UDRP Report

110, 116 York Street

RE: Response to UDRP Recommendations – April 4, 2025
110, 116 York Street

On behalf of Claridge Homes ("Claridge"), please find enclosed a response to Urban Design Review Panel Recommendations received following the Urban Design Review Panel hearing on April 4, 2025 at 9:00 am, in relation to the Official Plan Amendment (OPA), Zoning By-law Amendment (ZBLA) and Site Plan Control (SPC) applications for 110, 116 York Street.

Drawing Title
SITE PLAN

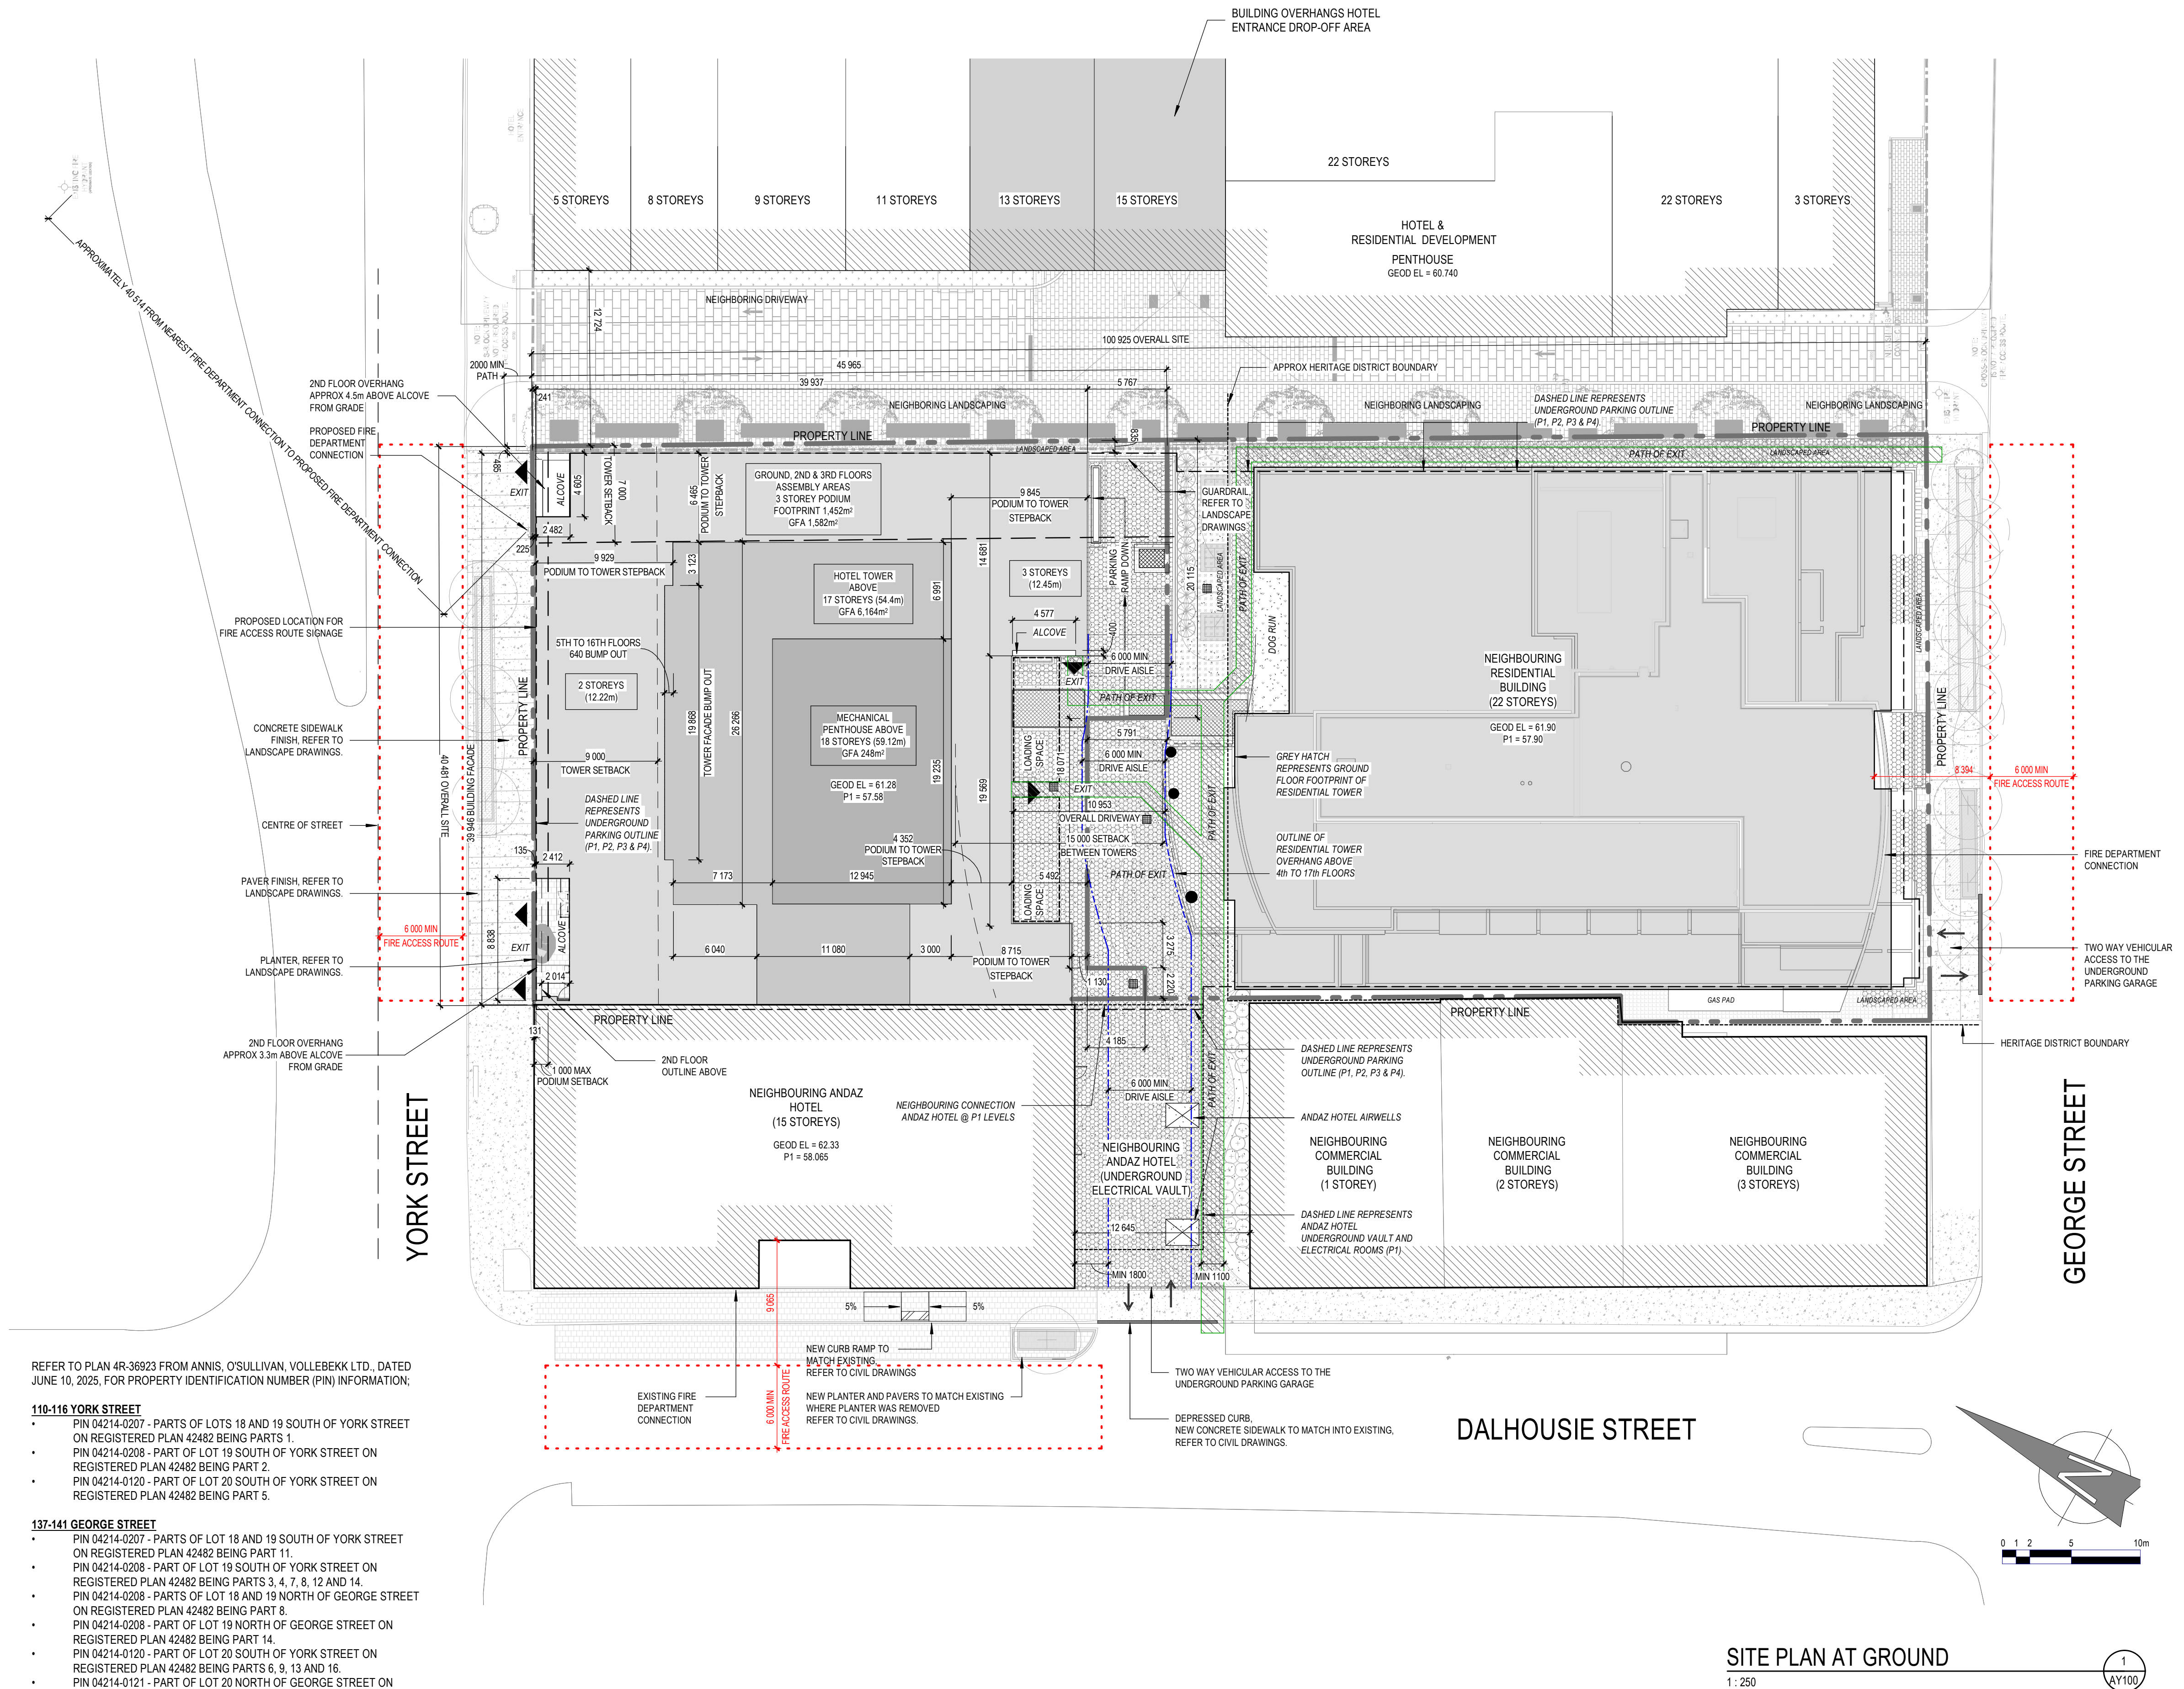
4. The Panel notes the need to resolve the function and character of the laneway in terms of public realm integration.

10. The Panel expresses concern with the laneway treatment at the rear of the site. While currently functioning as a service zone, the proposed paving patterns suggest pedestrian use that is unsupported by program, animation or safety measures.

/ The Panel suggests that the design intent should be clarified—either refine it as a high-quality service lane or transform it into a shared space that accommodates both people and vehicles with appropriate design cues.

Response: As indicated in the site plan, the primary function of the laneway between 325 Dalhousie Street, 110-116 York Street, and 137-141 George Street is a drive aisle leading to a ramp to the shared underground parking garage, loading spaces, and waste staging area for private collection. This space is primarily utilitarian, but the landscaping aims to make it visually appealing for overlooking users of the multiple abutting high-rise towers. The space is not intended for public pedestrian use.

Response: Please refer to the response to Comment 4. The laneway is a high-quality service lane and access to the parking garage. Design elements are incorporated to make it visually appealing to residents and hotel guests in the surrounding buildings.

SOUTH ELEVATION
1:150

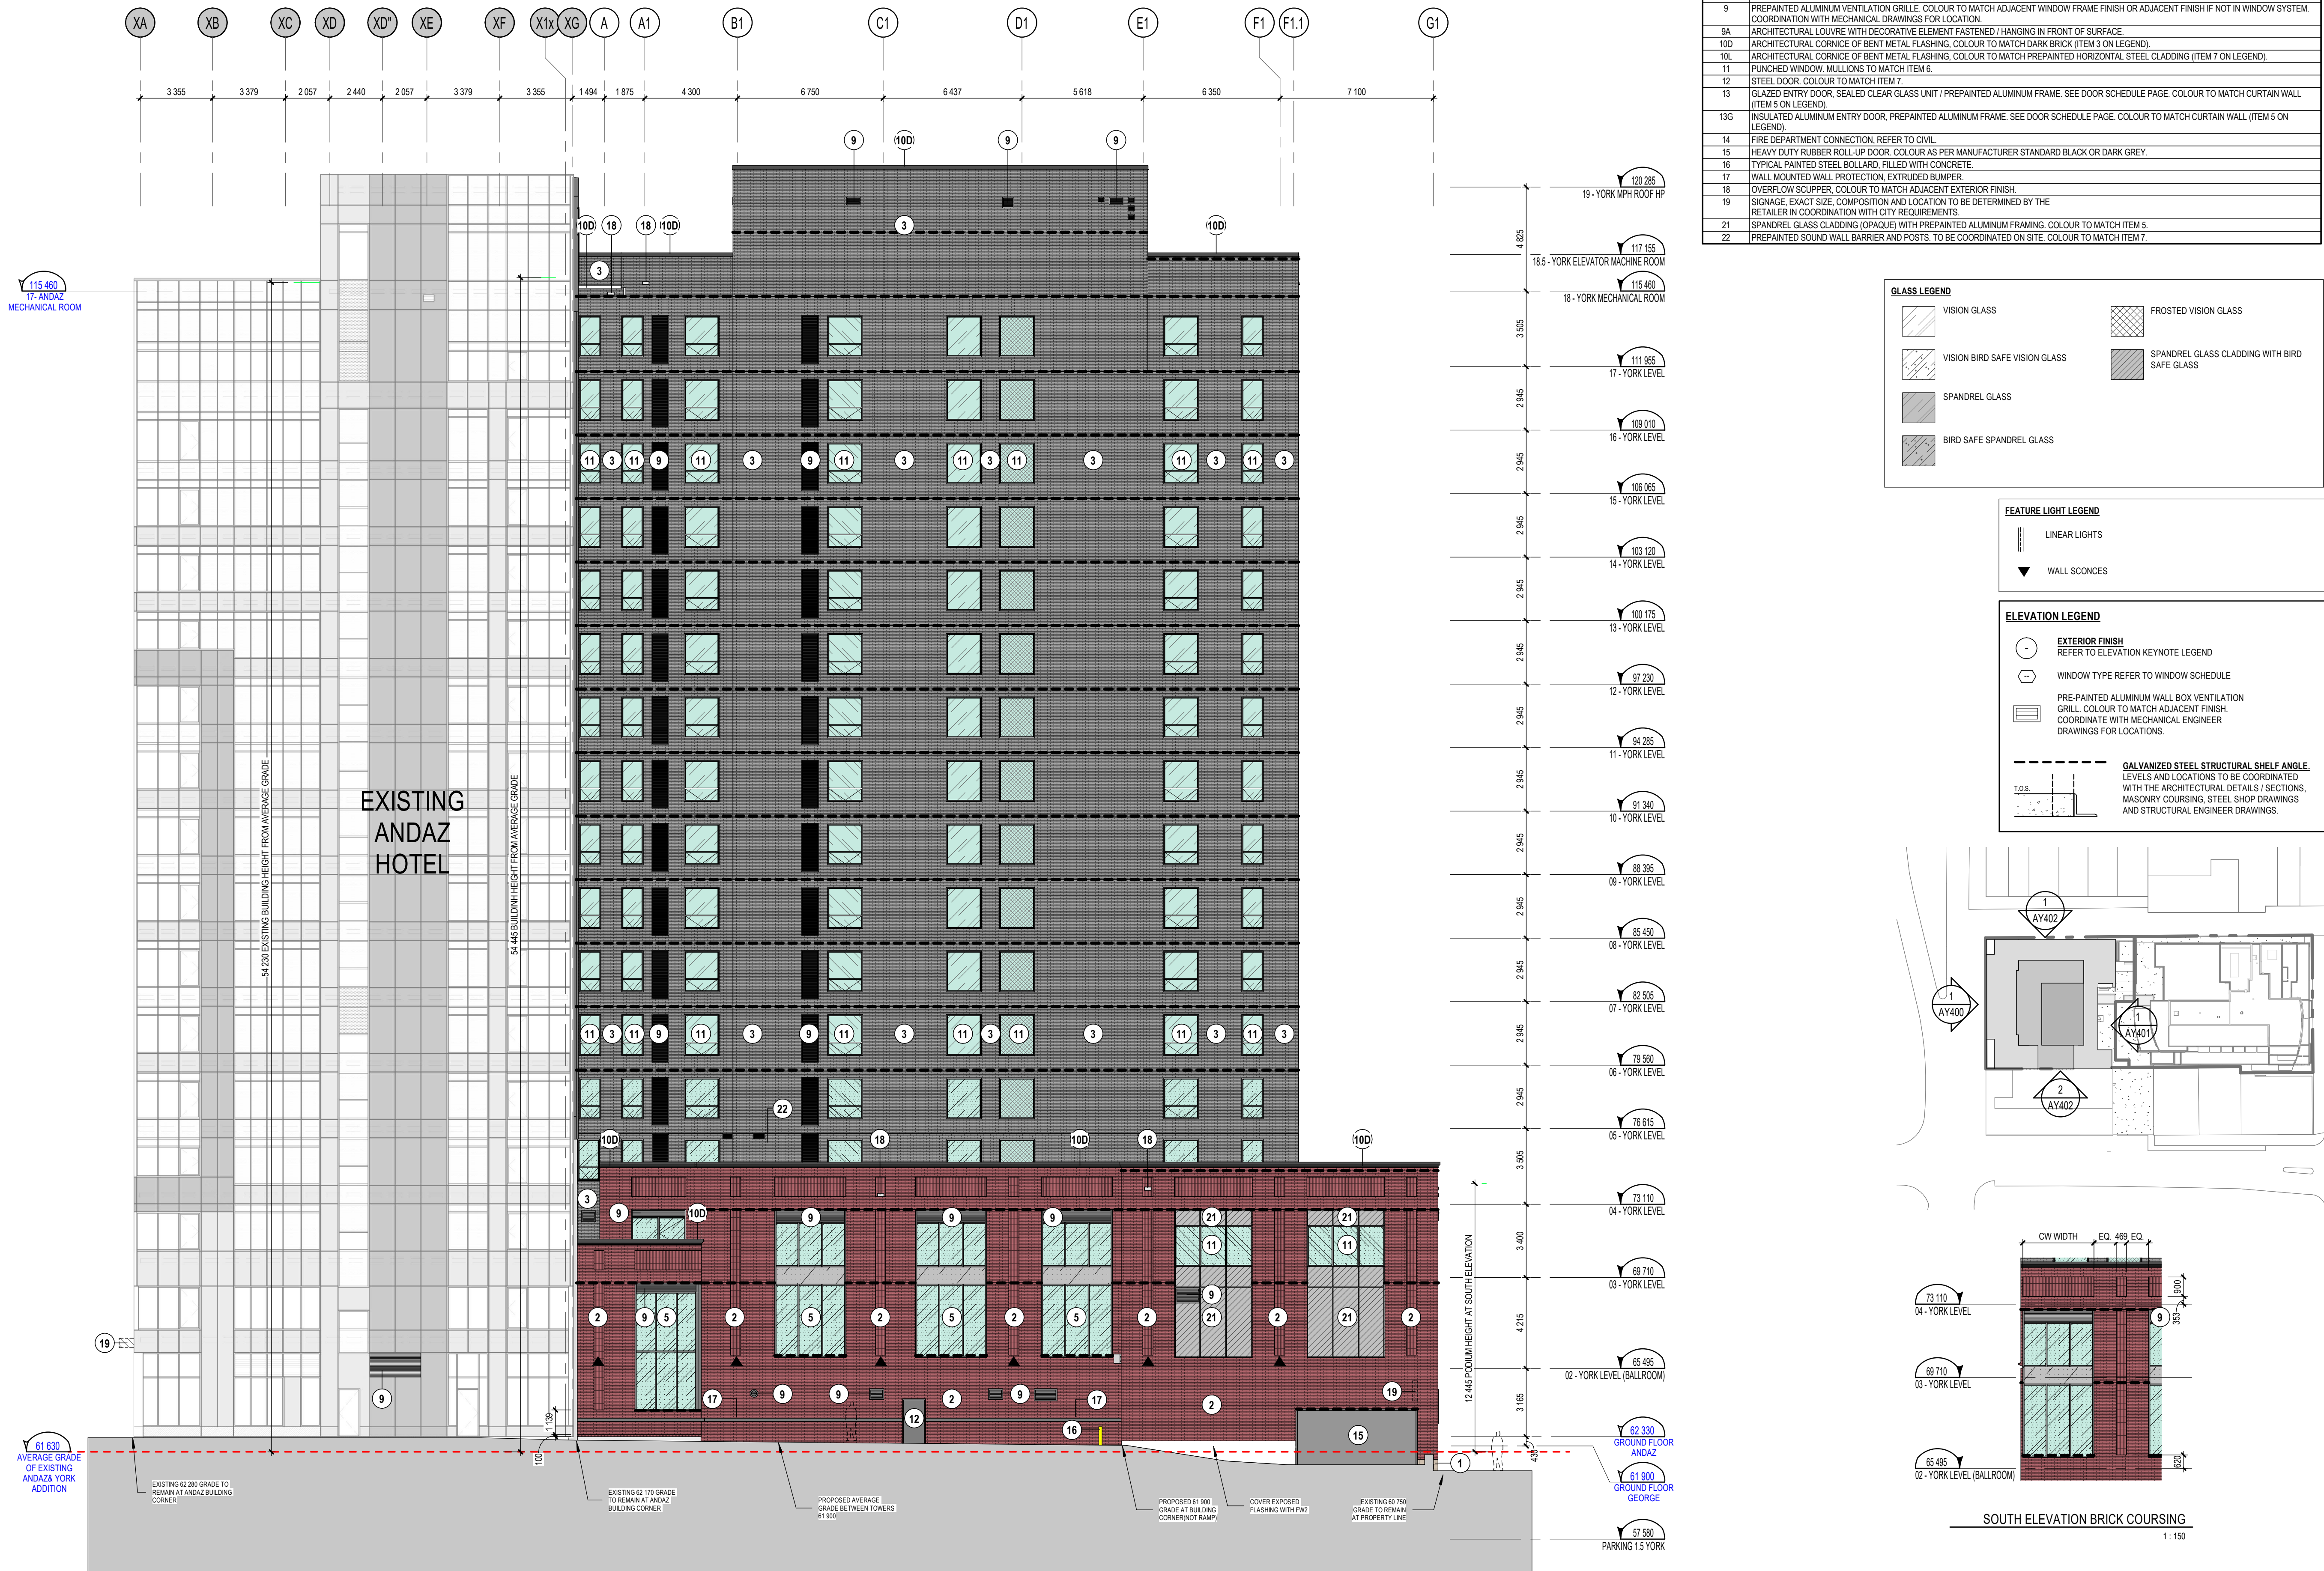
3. The Panel has concerns with the elevation difference between the finished floor elevation of the ground floor and the exterior public realm and suggests that this should be carefully reconciled to enhance the relationship with the future street condition. The entrances should also be made more prominent and welcoming to strengthen the building's interface with the public realm.

12. The Panel encourages stronger architectural articulation at both the podium and tower levels.

/ The current podium is perceived as overly flat and lacking the richness and solidity expected within a historic urban context. Greater detailing and modulation are recommended to better reflect the scale and texture of the surrounding buildings.

/ A more human-scaled approach with finer-grained detailing and varied materiality is suggested to enhance the pedestrian experience.

Response: Windowsills along York Street have been lowered to the finished floor to reduce the height difference to grade and emphasize visual engagement between the streetscape and building program. The ground floor alignment against the sloped grade maximizes accessibility throughout the floor plan. Lighting and signage above the entrance alcove will clarify the building interface with the public realm.

Response: A decorative cornice is applied to the podium parapet and brick recesses around podium windows are shown on elevations. The glass volume over the main entrance will be recessed back to create variety between the existing Andaz and new brick podium facades.

Response: Acknowledged. Windowsills along York Street will be lowered to finished floor to reduce the height difference to grade and emphasize visual engagement and the building entrance will be recessed to create a more varied interface with the public realm.
